Our ref: HA/2015/117488/01-L01
Your ref: P/94/15/PL
Date: 02 October 2015

**3 NO. DETACHED BUNGALOWS WITH GARAGE, PARKING & DECK
(RESUBMISSION FOLLOWING P/12/15/PL)
LAND TO EAST OF 29 HARBOUR ROAD PAGHAM PO21 4TF**

Environment Agency position

STREET SCENE — Harbour Road.
with levels (A.O.D.)
Scale 1:100

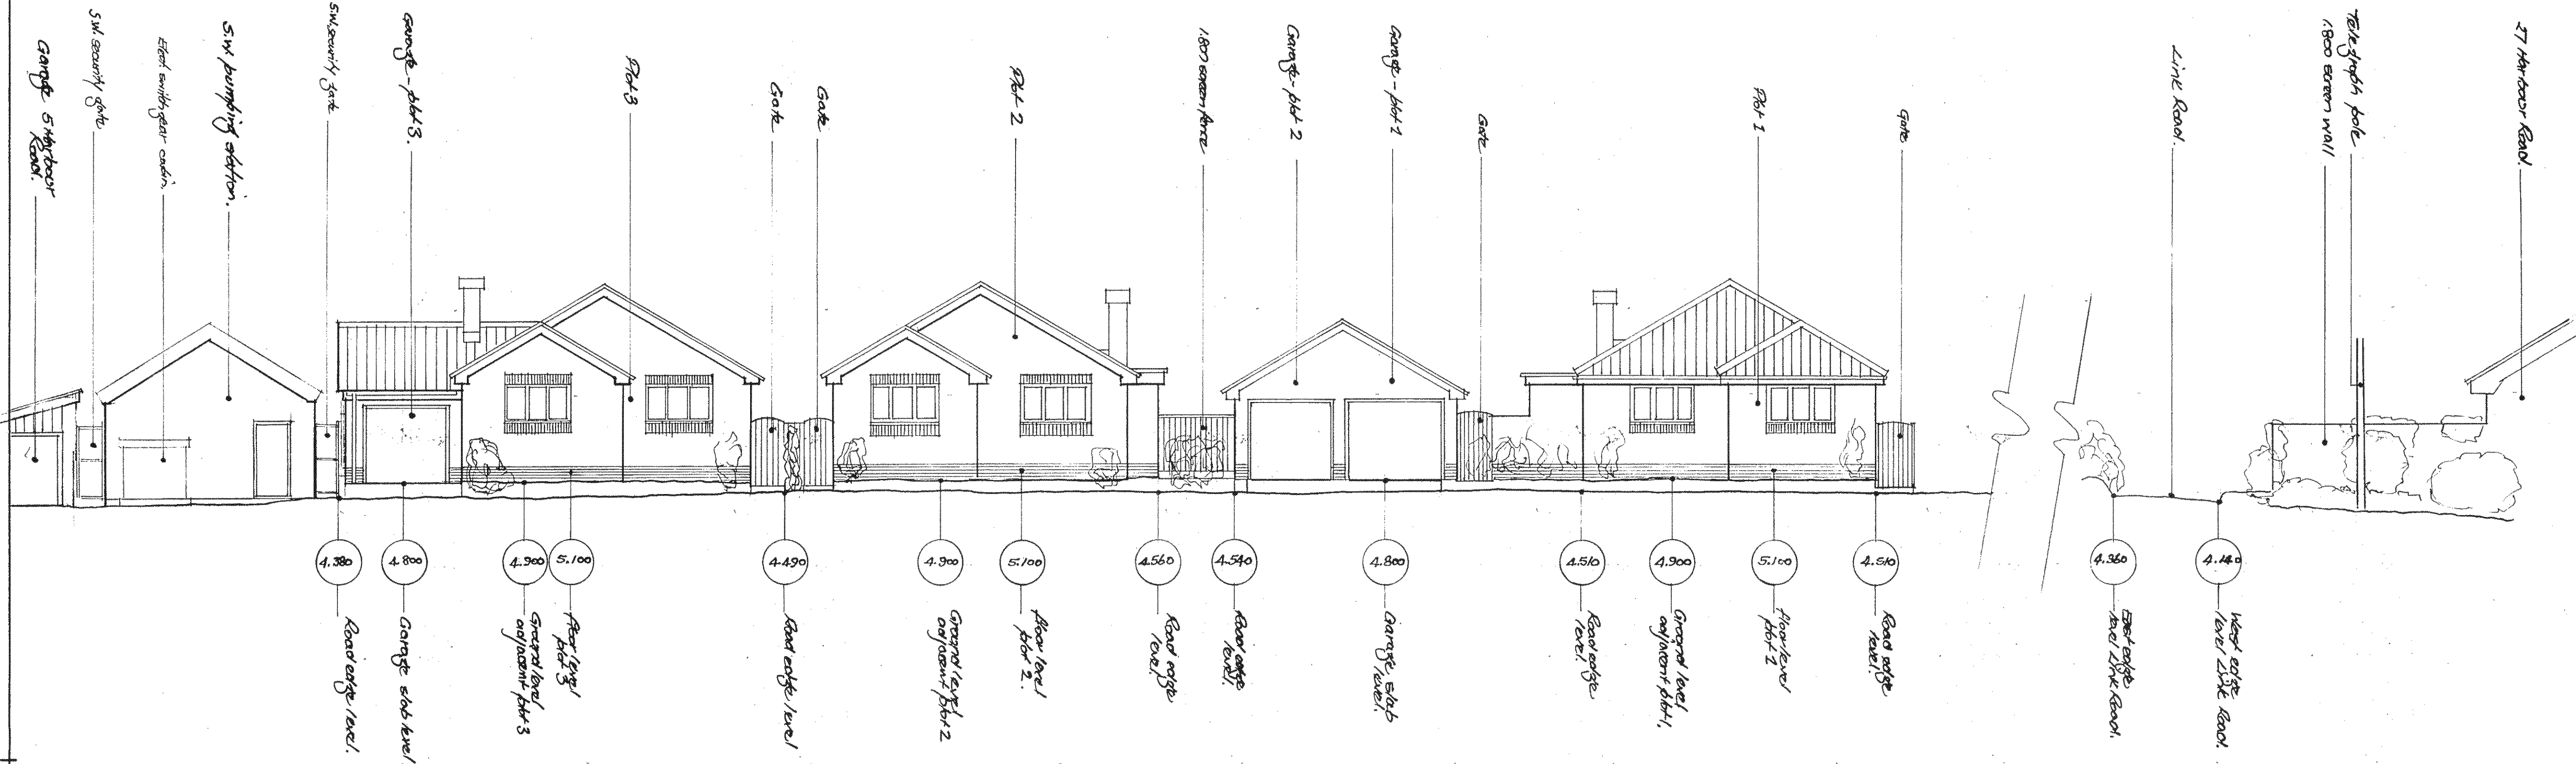
1. *Finished floor levels are set no lower than 5.5m above Ordnance Datum (AOD).*
- The mitigation measures shall be fully implemented prior to occupation and subsequently in accordance with the timing / phasing arrangements embodied within the scheme, or within any other period as may subsequently be agreed, in writing, by the local planning authority.
